**Application for Works to Trees(s) subject to a Tree Preservation Order(TPO)**

**Development:** Crown reduction to 2 No. Copper Beech (T2) to leave a height of \_\_\_ and spread of \_\_\_.  
Crown reduction to 1 No. Acacia tree (T1) to leave a height of \_\_\_ and spread of \_\_\_.  
Removal of dead shrub.  
**Location:** 126 Sea Lane Rustington BN16 2RZ

Have attached photos of T1 (acacia at front of house)

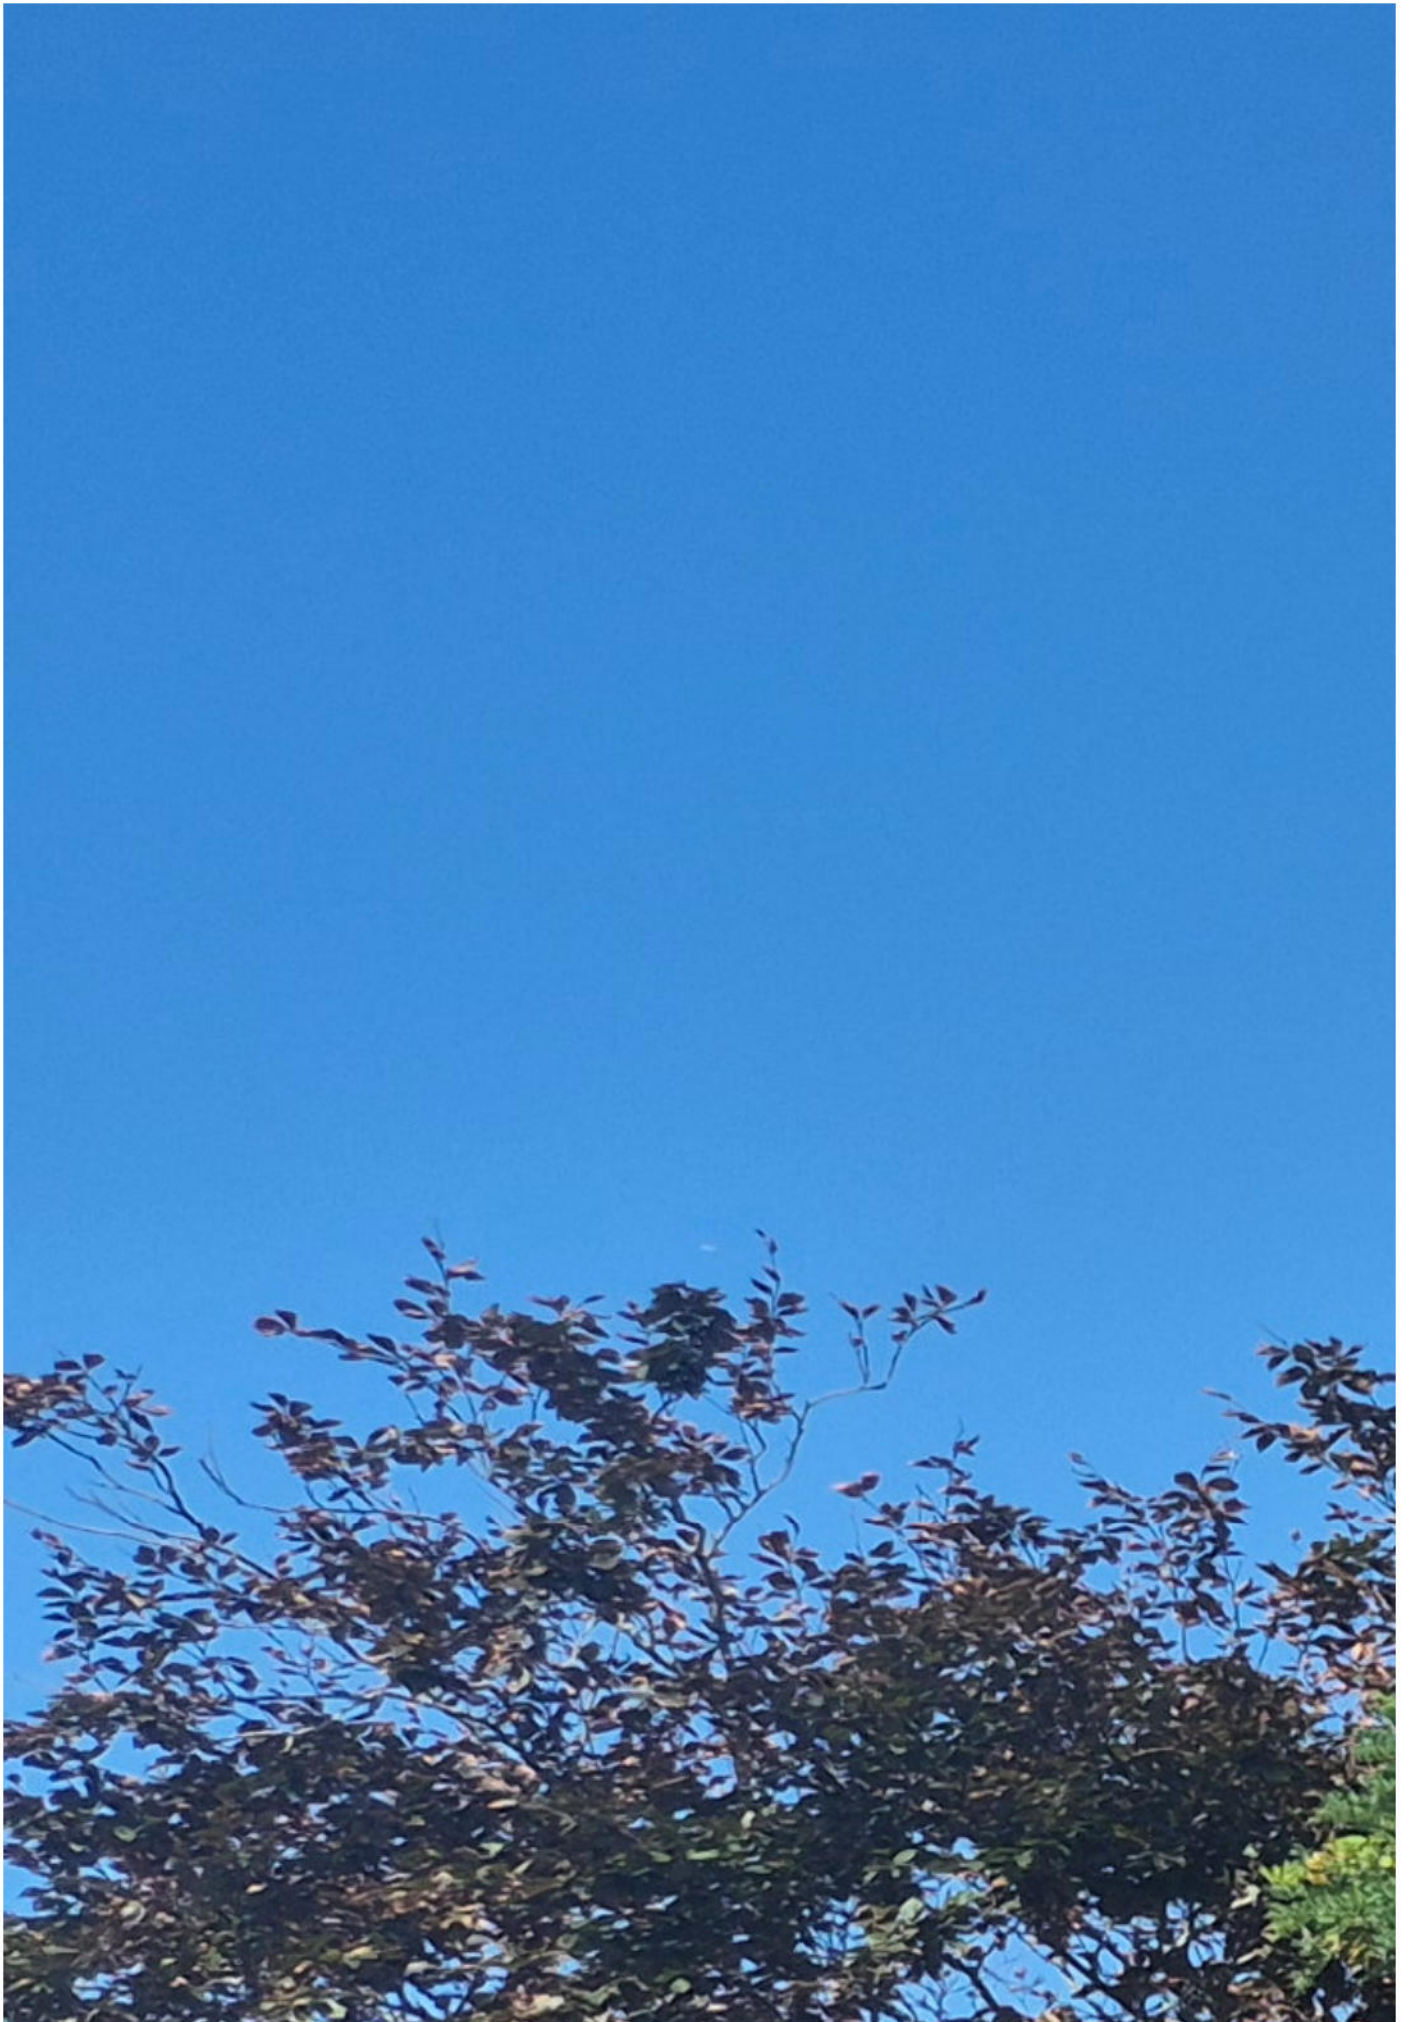
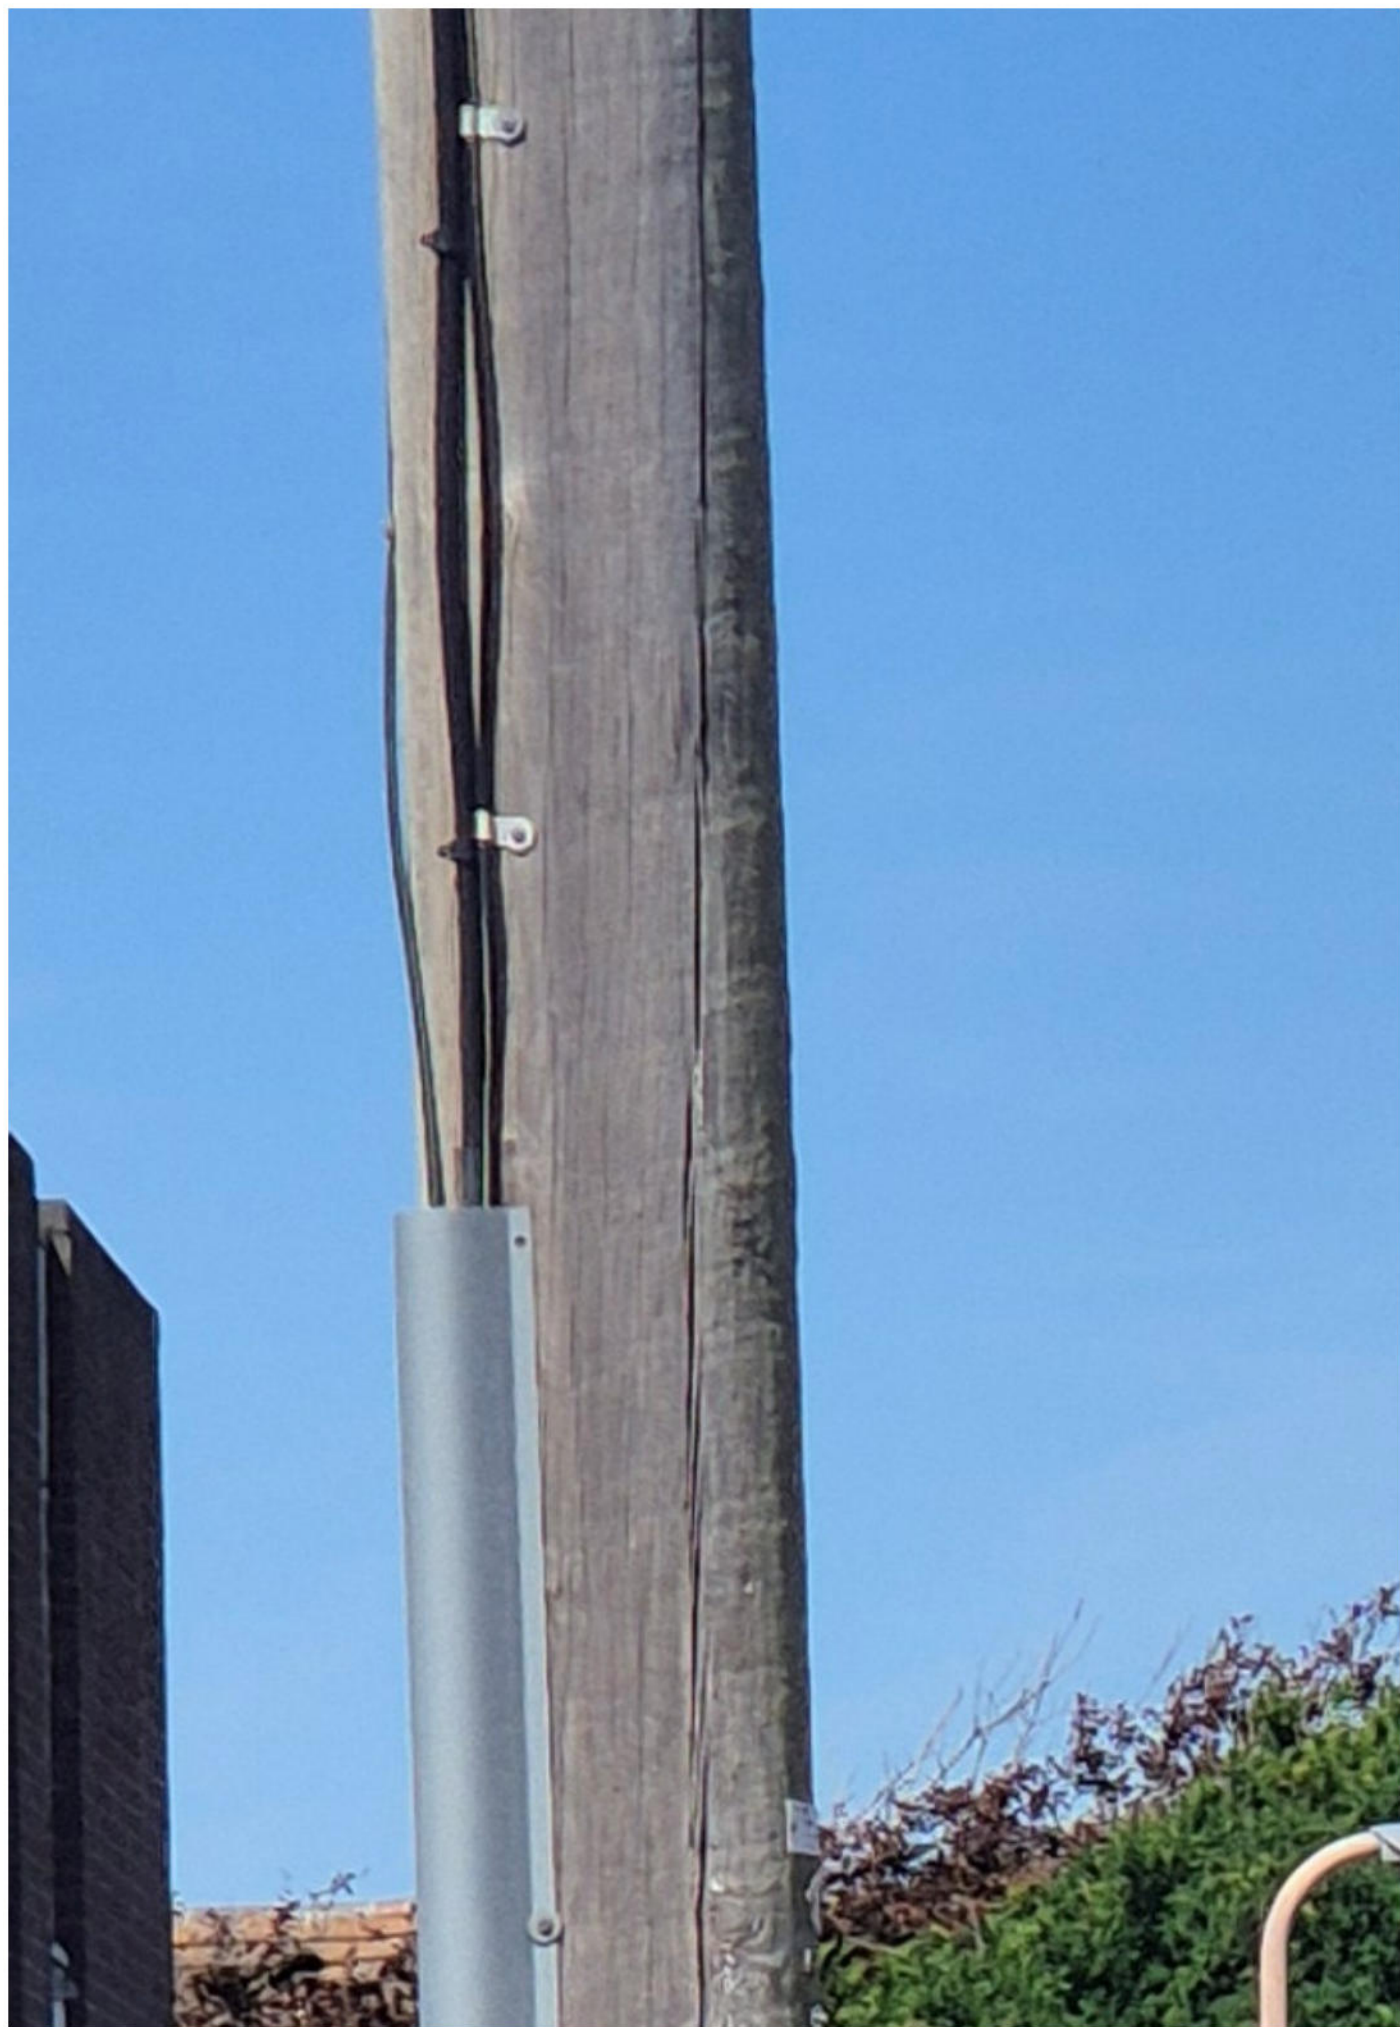
Please clarify the height and spread of the trees after the proposed works.
